## BCA ASSESSMENT REPORT

OAKDALE SOUTH ESTATE  
SITE 3A - SIGMA  
MILNER AVENUE, HORSLEY PARK

PREPARED FOR:  
GOODMAN PROPERTY SERVICES (AUST) PTY LTD

Revision 2

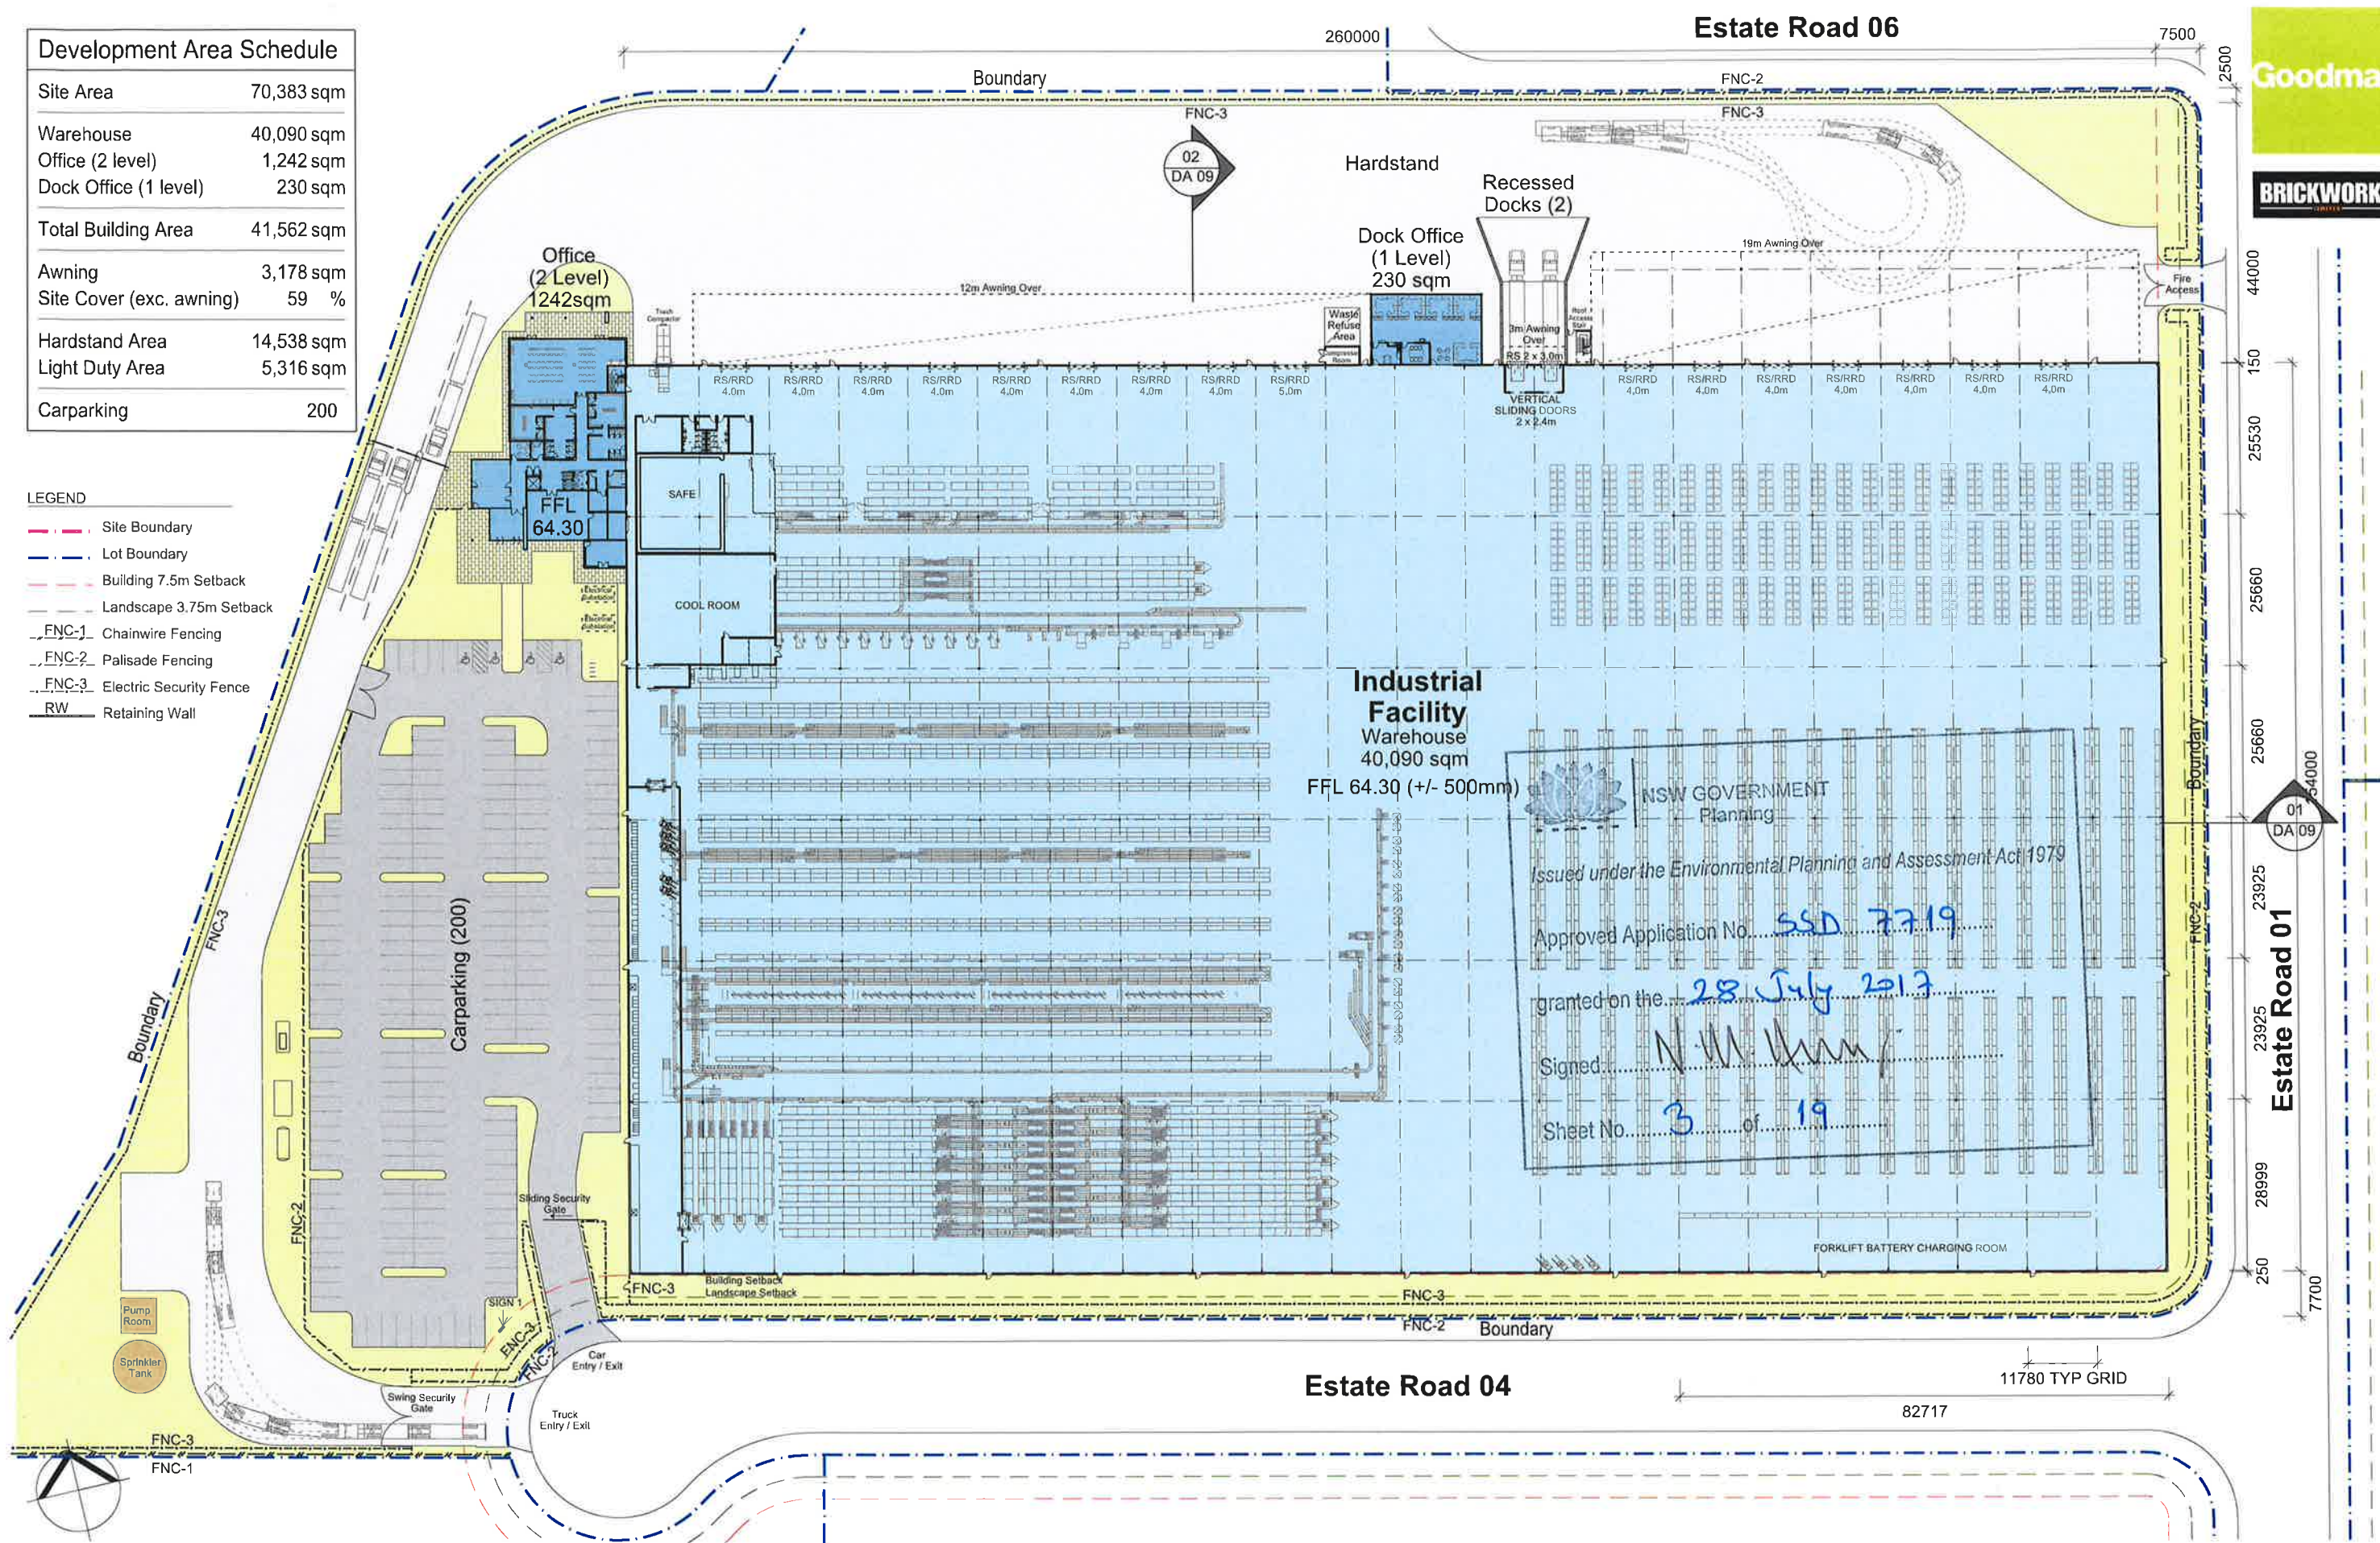
*Comments: It will be necessary for an alternative solution to be prepared to address these non-compliance issues below, in order to demonstrate compliance with Performance Requirement CP9. The departures from this clause are as follows:*

- + The vehicle access in the SW corner and western side of the building is greater than 18m from the building as circled below.
